State of Washington
DEPARTMENT OF FISH AND WILDLIFE

January 9, 2024

SUBJECT: WDFW COMMENTS ON CU-23-00007 Cle Elum Transfer Station

**JACOBS**  
 CIVIL  
**OVERALL EXISTING SITE PLAN**

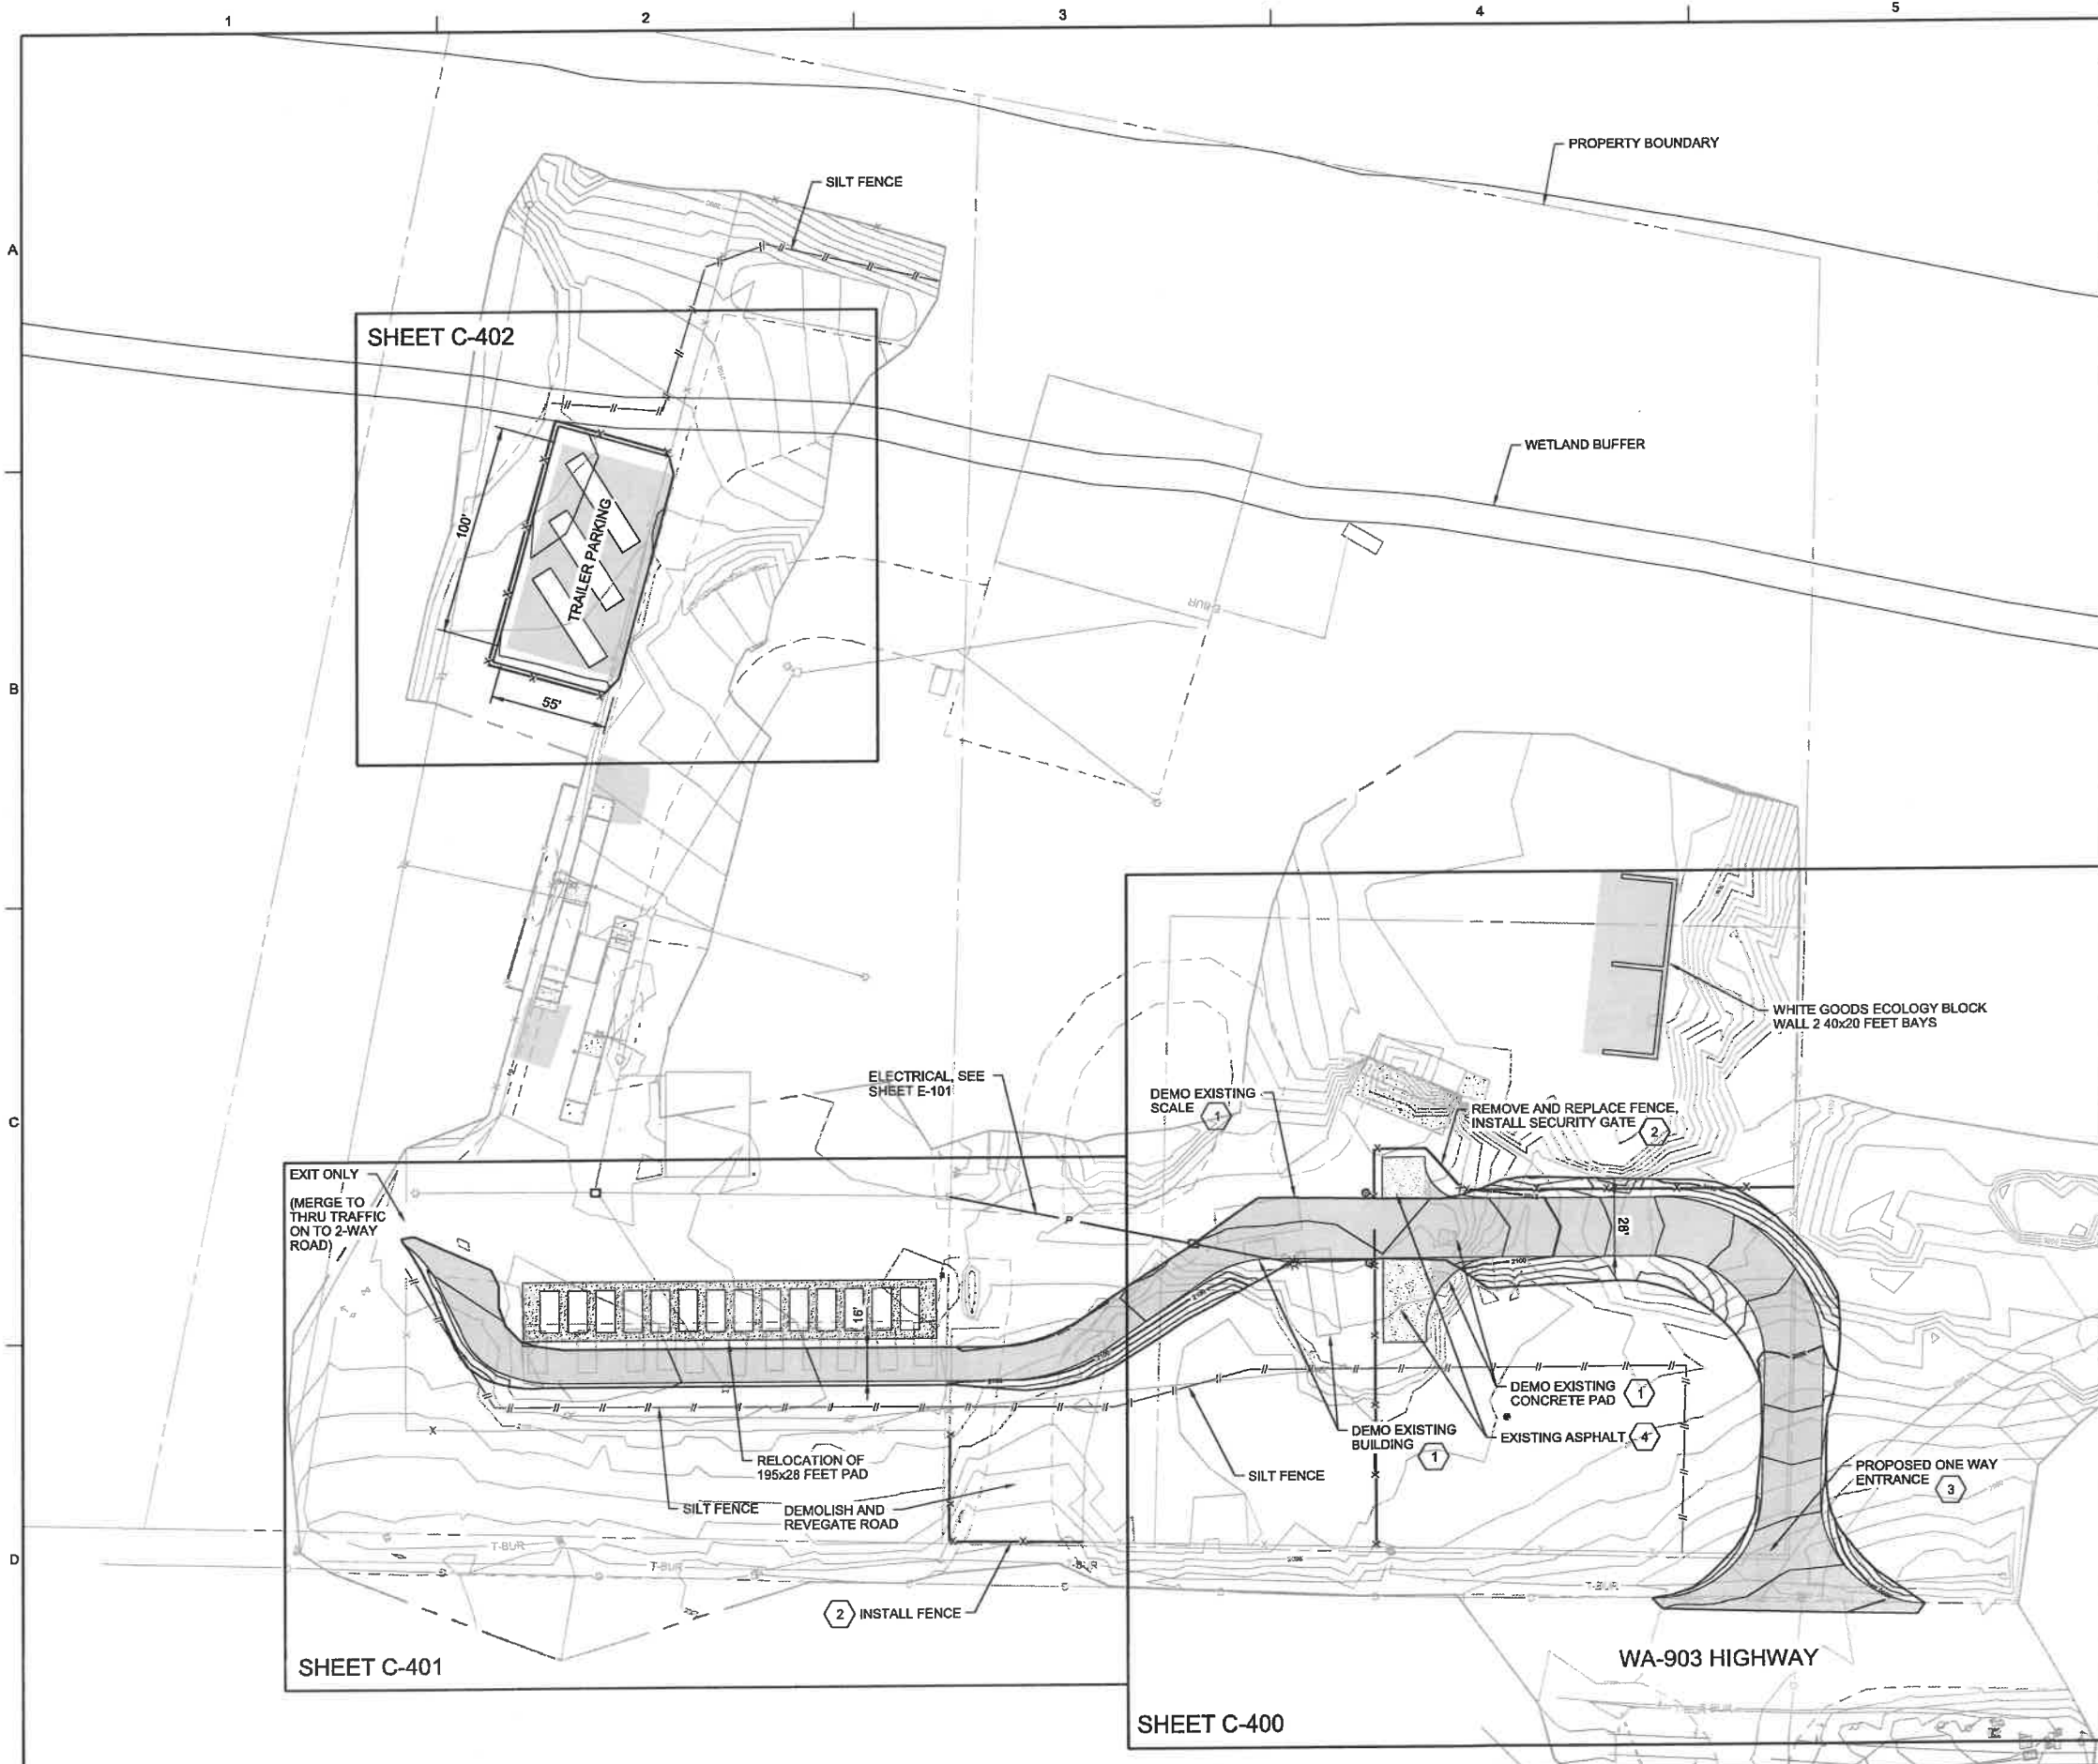
The site plan sheets are unclear, but there appears to be potential overlap between the clearing limits for the building of the trailer parking and the riparian area of Crystal Creek. WDFW requests the opportunity to meet with the applicant, preferably on site, to clarify clearing limits in respect to the riparian zone of Crystal Creek. If the proposed clearing limits do overlap with the riparian setbacks for a Type F stream, WDFW requests that either the clearing limits be modified to have no impact or for the applicant to prepare a mitigation proposal to offset the impacts of the clearing. Further, while not part of the proposed application there are existing impervious surfaces within the riparian area of Crystal Creek. WDFW would recommend to explore if those areas could be revised and potentially rehabilitated to provide riparian habitat. WDFW requests that exploring that possibility also be part of the proposed meeting.
